DEVELOPMENT HEARING OFFICER

PR-2018-001579

SD-2024-00179 – VACATION OF PRIVATE
EASEMENT SD-2024-00118– MINOR
AMENDMENT TO PRELIMINARY/FINAL PLAT
IDO – 2022 SKETCH 10-18-23 (DFT)

REQUEST: Vacate existing private access easement and rename Parcel to E-1-A-1

**PRELIMINARY PLAT  
 PARCEL E-1-A  
 WINROCK CENTER ADDITION**

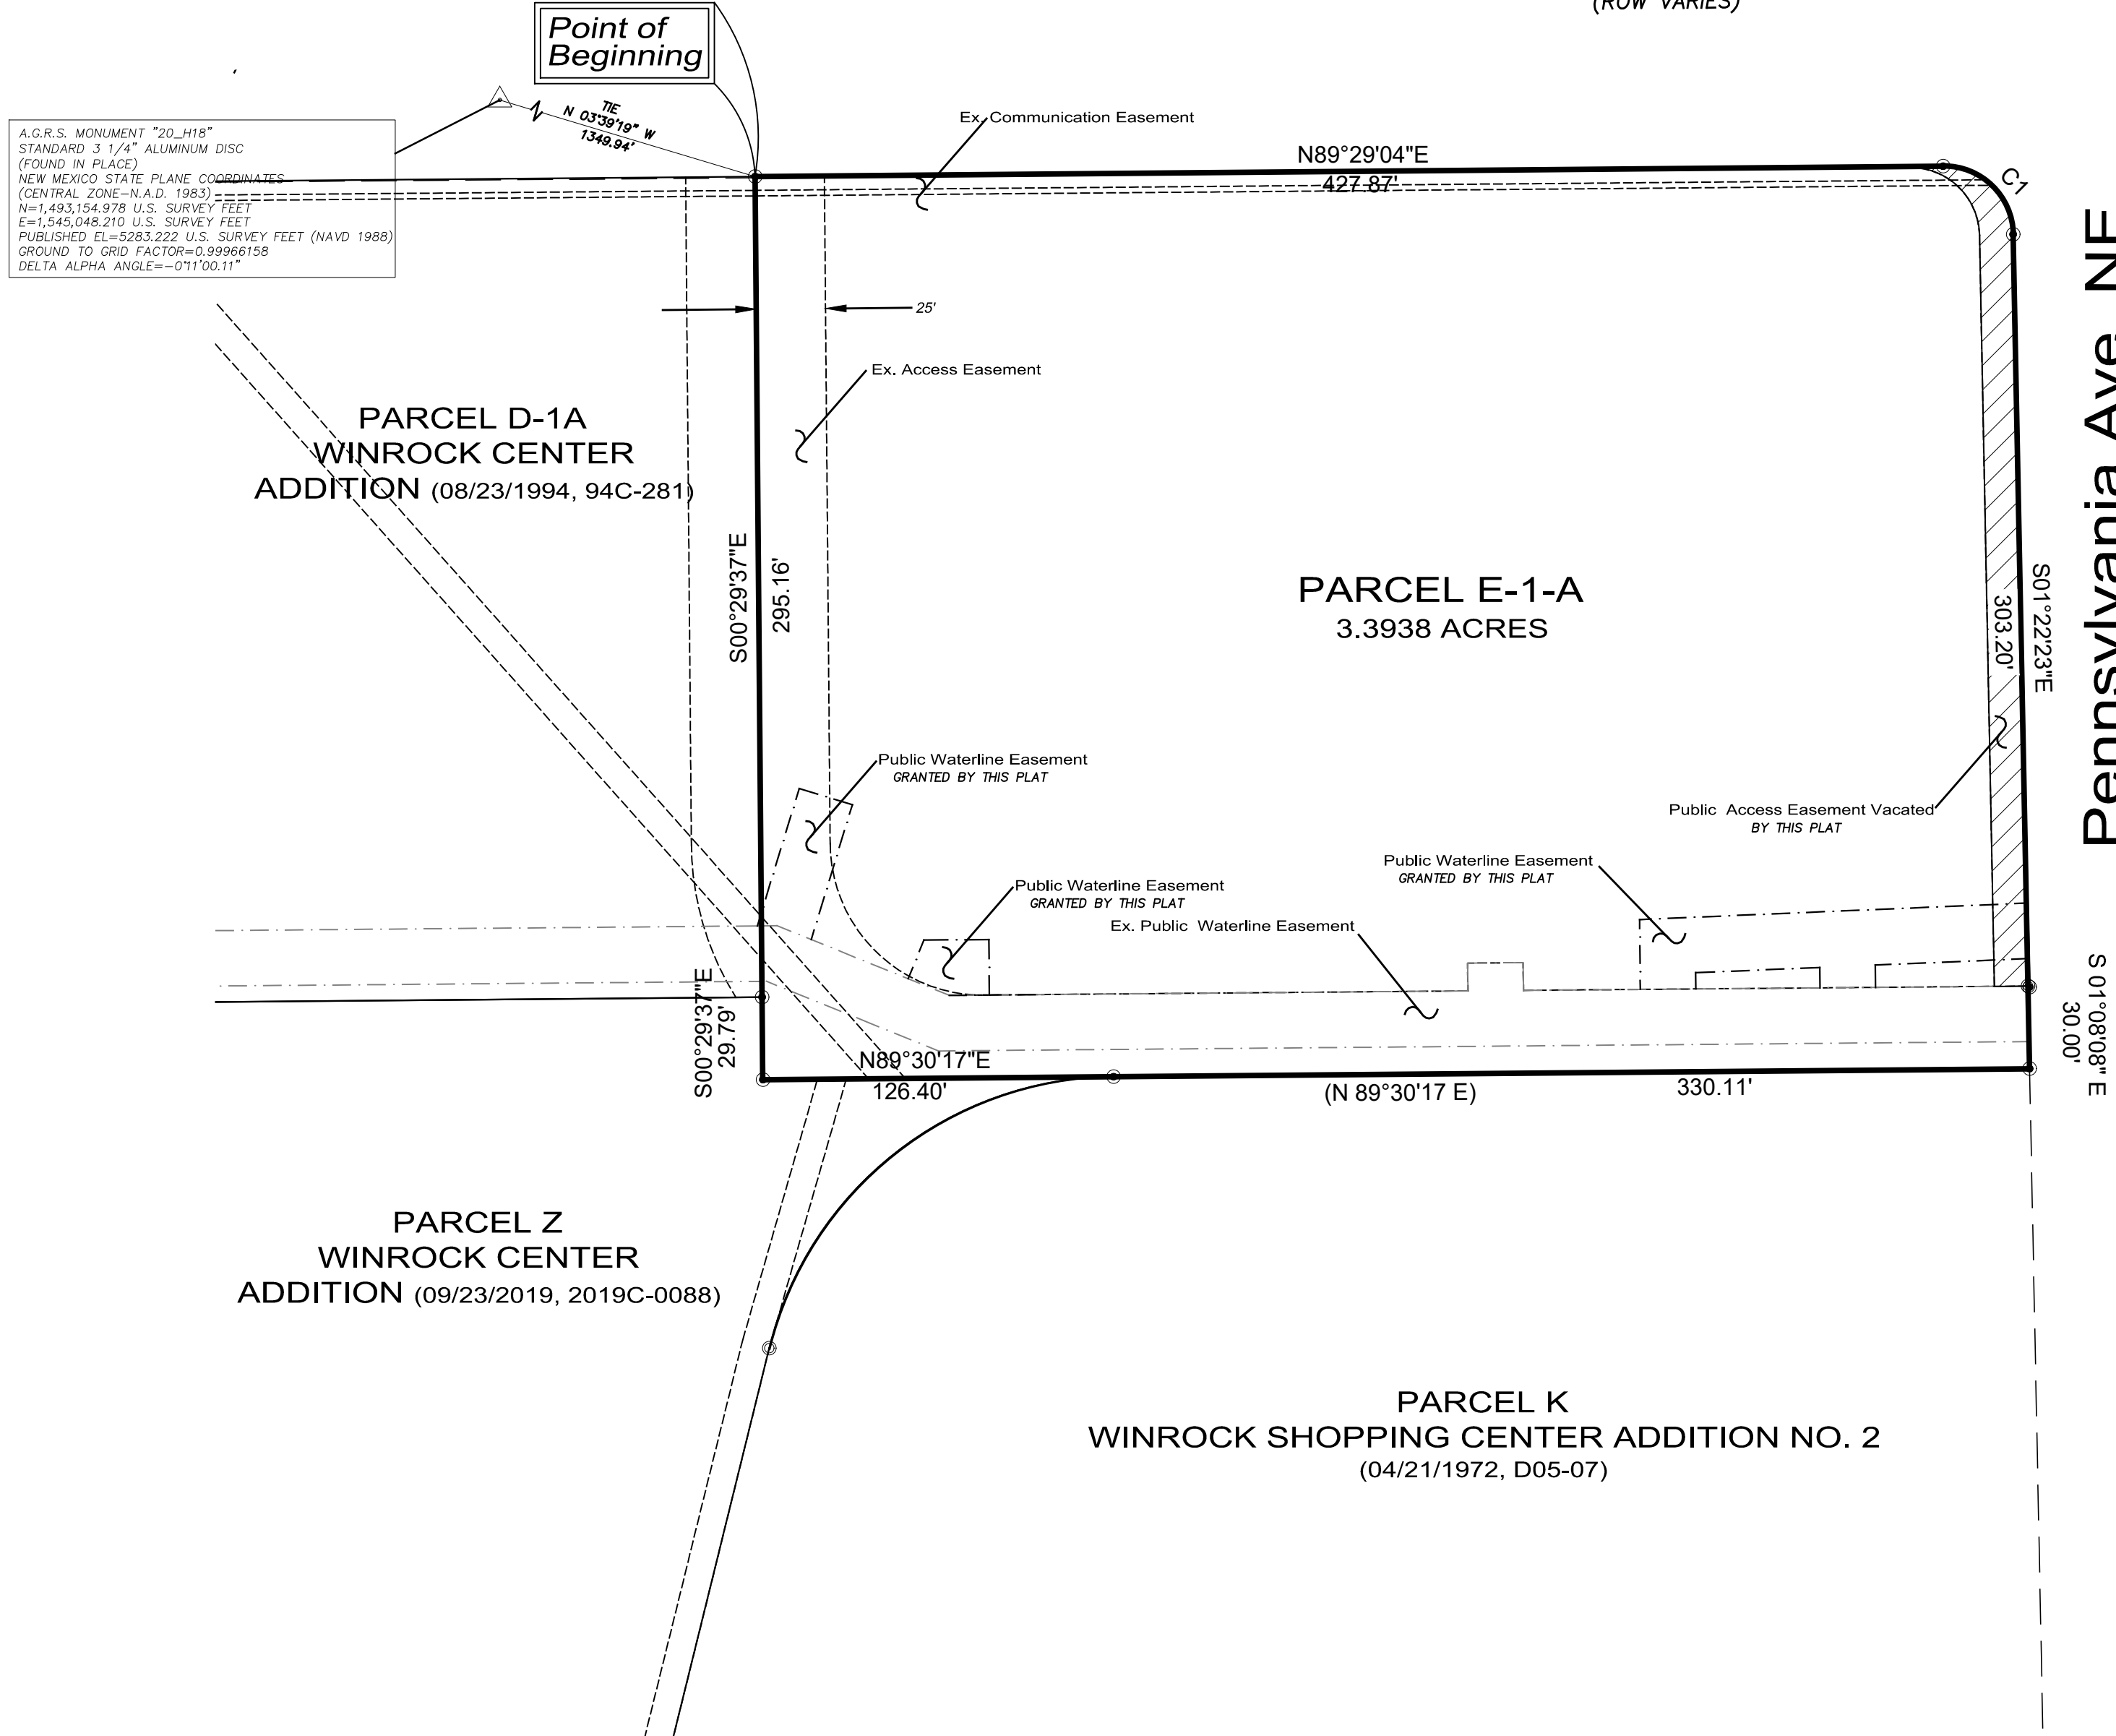
Additionally, during the review of the current platting application, staff noticed that the parcel number on that Plat has not been changed from "Parcel E-1-A" to another number to note the replat; for example, the new parcel number might be changed to "Parcel E-1-A-1." **Planning staff recommend that as a condition of approval of the current Plat, a Minor Amendment to the Preliminary/Final Plat for PR-2018-001579 / SD-2021-00073 be submitted for DHO review and approval to revise the number of the replatted parcel from "Parcel E-1-A," the conditions of approval for PR-2018-001579 / SD-2021-00073 be addressed/met (such as addressing ABCWUA comments), and the Plat recorded.** Alternatively, the Applicant could choose to withdraw the Plat for PR-2018-001579 / SD-2021-00073 and re-apply for the Vacation of a Public Access Easement for a deceleration lane along Pennsylvania Street NE for DHO review and approval.

- This Plat depicts the vacation of a private access easement along the southern boundary of the subject property; while noted in the October 18th, 2023 Sketch Plat previously reviewed by DFT staff, a separate Vacation application has not been submitted to and approved by the DHO (or DRB previously). Therefore, **prior to the approval of this Plat, a Vacation of Private Easement application for the noted private access easement must be submitted and approved by the DHO** (could be approved concurrently with this platting application).

- The project and application numbers for the Plat for PR-2018-001579 / SD-2024-00112 must be corrected prior to distribution of the Plat for DFT/City Engineer signatures.

- The parcel number created by this replat must be revised to accommodate the previous replat for PR-2018-001579 / SD-2021-00073 as well as the current replat.
7/15/24 Update: The replatted lot on the Amended Preliminary/Final Plat for PR-2018-001579 / SD-2024-00118 is named "Parcel E-1-A-1", so **the Preliminary/Final Plat for PR-2018-001579 / SD-2024-00112 must be renamed from "Parcel E-1-A" to accommodate the replat for PR-2018-001579 / SD-2024-00118 prior to final sign-off of the Plat.**

7/15/24 Update: The agent for the application has submitted a Minor Amendment application to the Preliminary/Final Plat for PR-2018-001579 / SD-2021-00073 per previous Planning comments (the new application number for the amended Plat is SD-2024-00118).

7/15/24 Update: The agent for the application has submitted a Vacation of Private Easement application per previous Planning comments.
